**From:** Cherne, Curtis  
**Sent:** Wednesday, February 04, 2015 12:24 PM  
**To:** Reed, Keith; Biazar, Shahab  
**Cc:** Flores, David M.; Biazar, Shahab  
**Subject:** RE: San Antonio Trail

**Re: NM REGULATION & LICENSING OFFICE BUILDING**  
**5500 San Antonio Dr. NW**  
**Approval of Temporary Certificate of Occupancy (C.O.)**  
**Engineer's Stamp dated 12/03/2004 (E-18/D57/M)**  
**Certification dated 05/05/2005**

**Re: NM Regulation & Licensing Office Building, 5500 San Antonio NE,  
Grading and Drainage Plan, Engineer's Stamp dated 12-03-04 (E-  
18/D57A)**

TRACT A-3-B
 STATE OFFICE BUILDING
 GRADING AND DRAINAGE PLAN

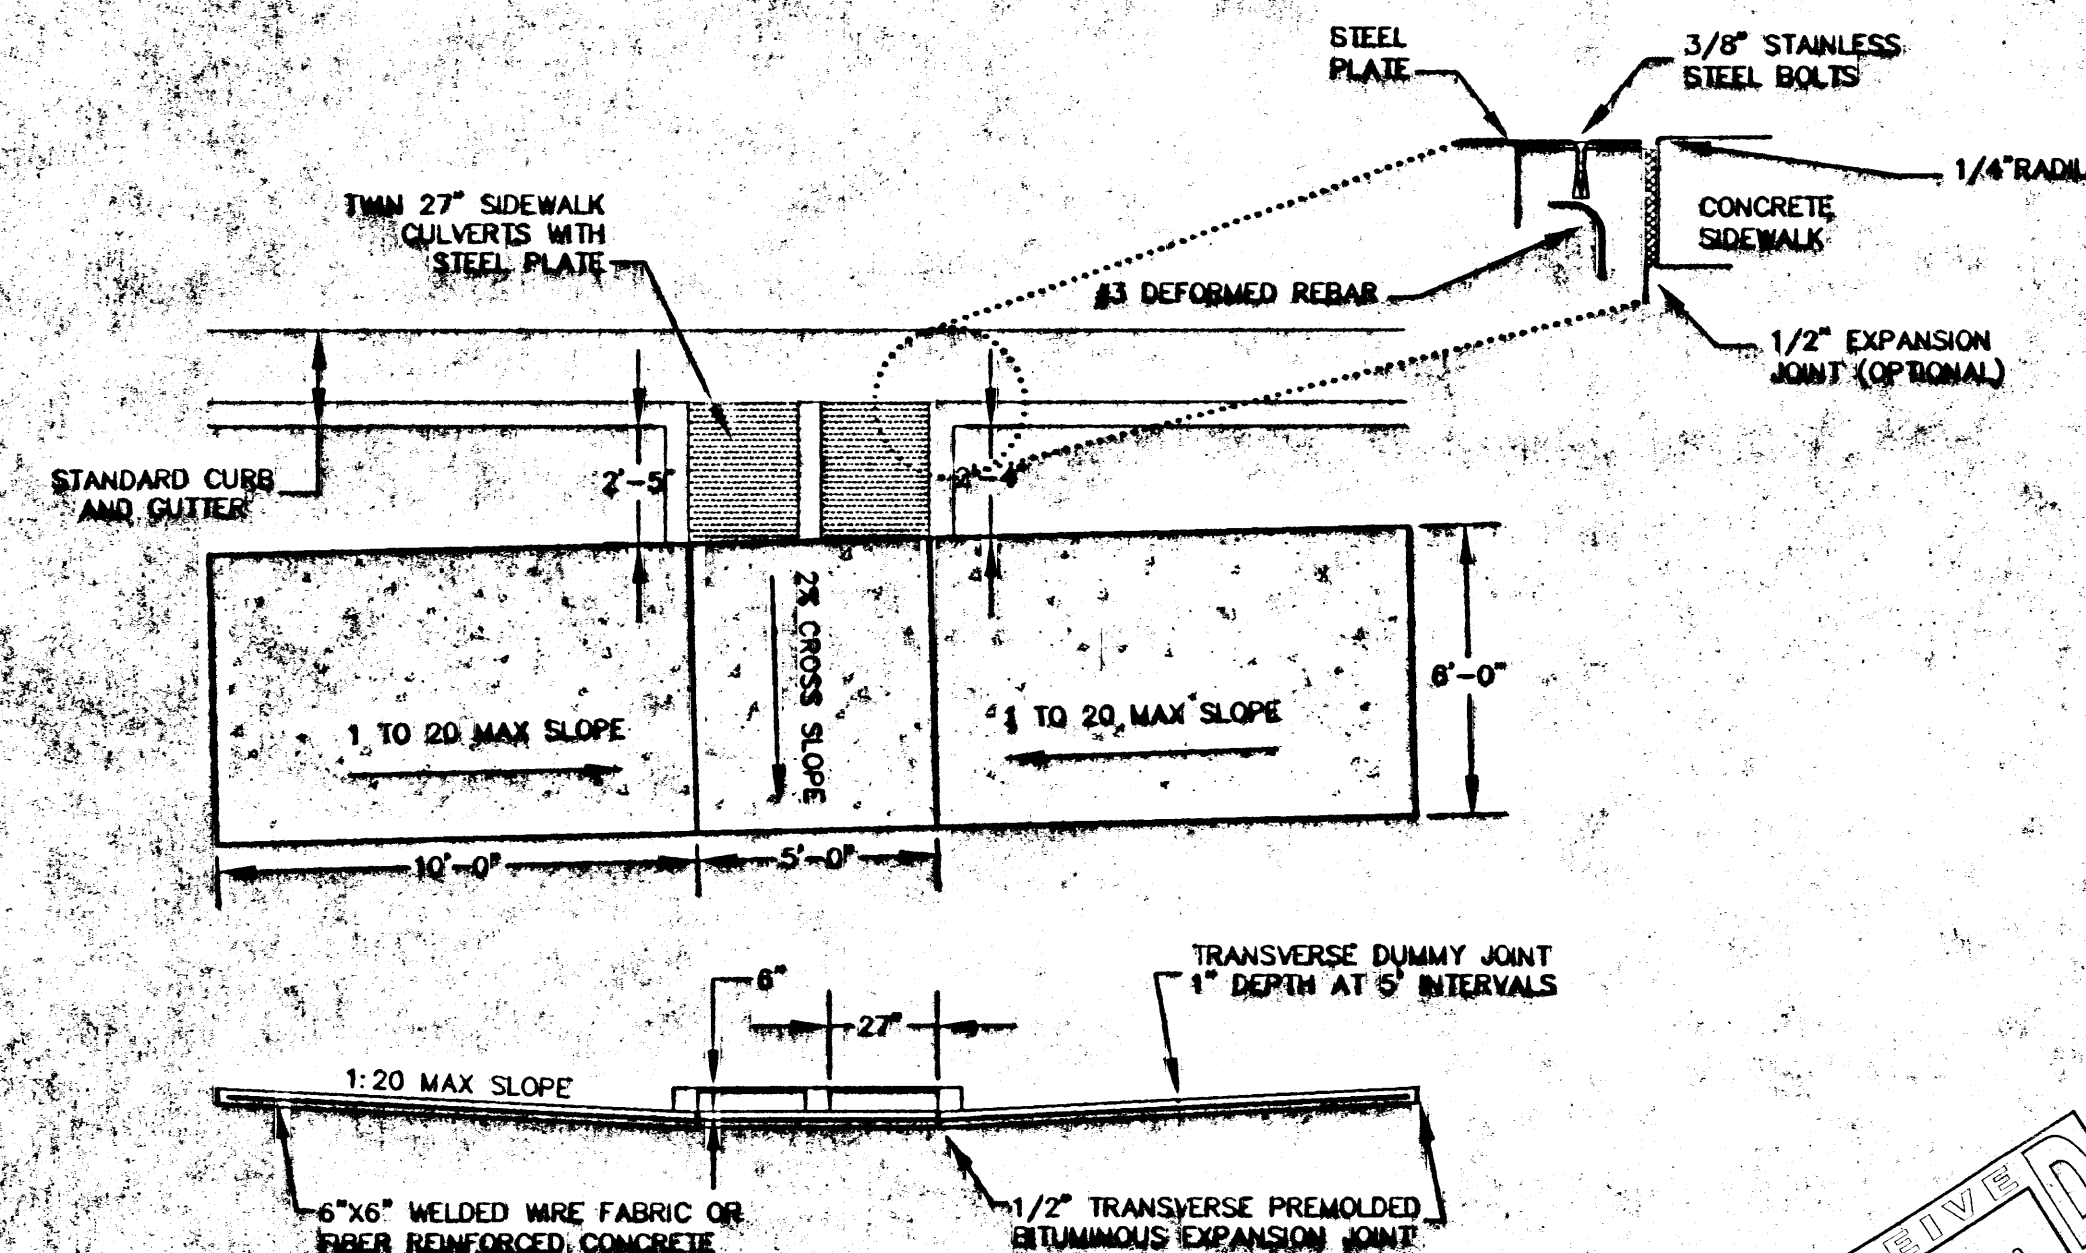
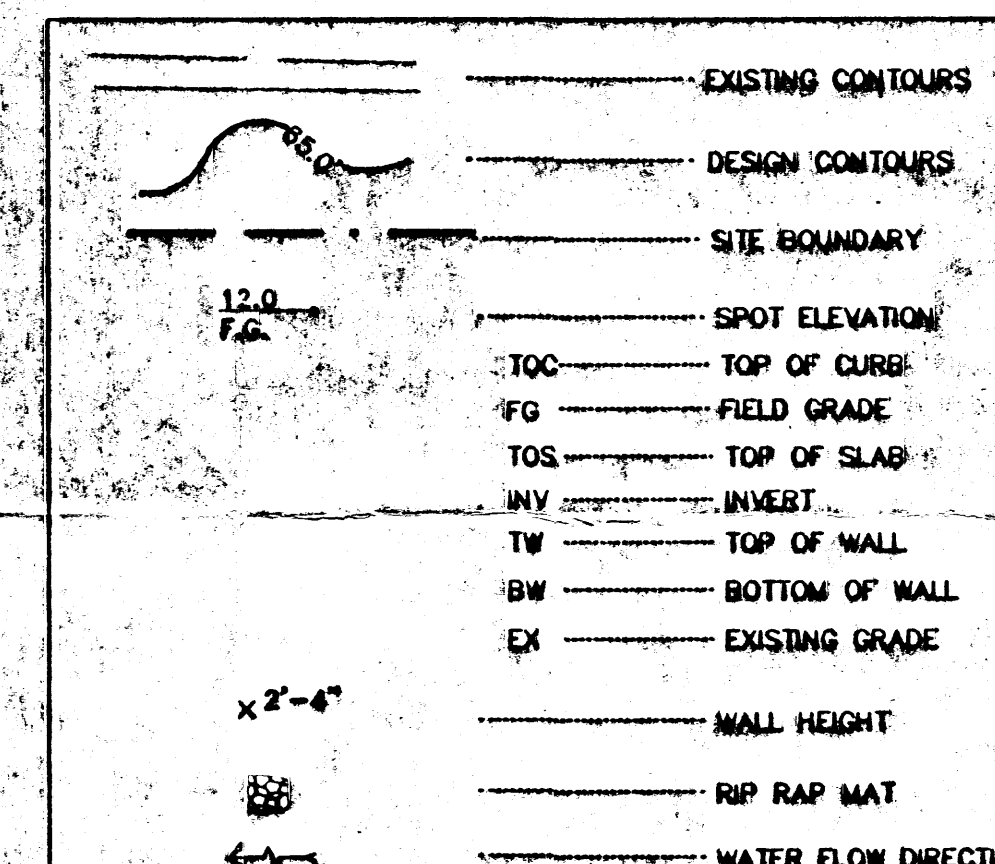
Per the approved grading plan for the Office of the State Engineer, the side inlet to the channel was built per CPN 735184. The slope is backwards, most likely due to settling which is due to the area being a former landfill. They are supposed to slope towards the channel at 2%.

Per the approved grading plan (E18D057) for the State Office Building (west of State Engineer), the drive aisle is to drain to the west to the side inlet, not south onto the bike trail.

Yes it would be acceptable to build a curb on your property. I take it you would go from the State Office Building low spot to the channel side inlet. One tricky thing is whether the curb, due to the weight of concrete, will sink as other things out there are.

It may be better to slope pave the area with an invert similar to a valley gutter rather than build a curb.

It would be preferable for the property owner to fix the issue on their side. Since this site is not draining per the approved drainage plan, the site is in violation of the Drainage Control Ordinance. In addition, it is causing damage to City property. Hydrology on the behalf of the City Engineer enforces the Drainage Control Ordinance when reviewing plans as well as with drainage problems. However, anyone can use the Drainage Control Ordinance if their property is adversely affected by development.
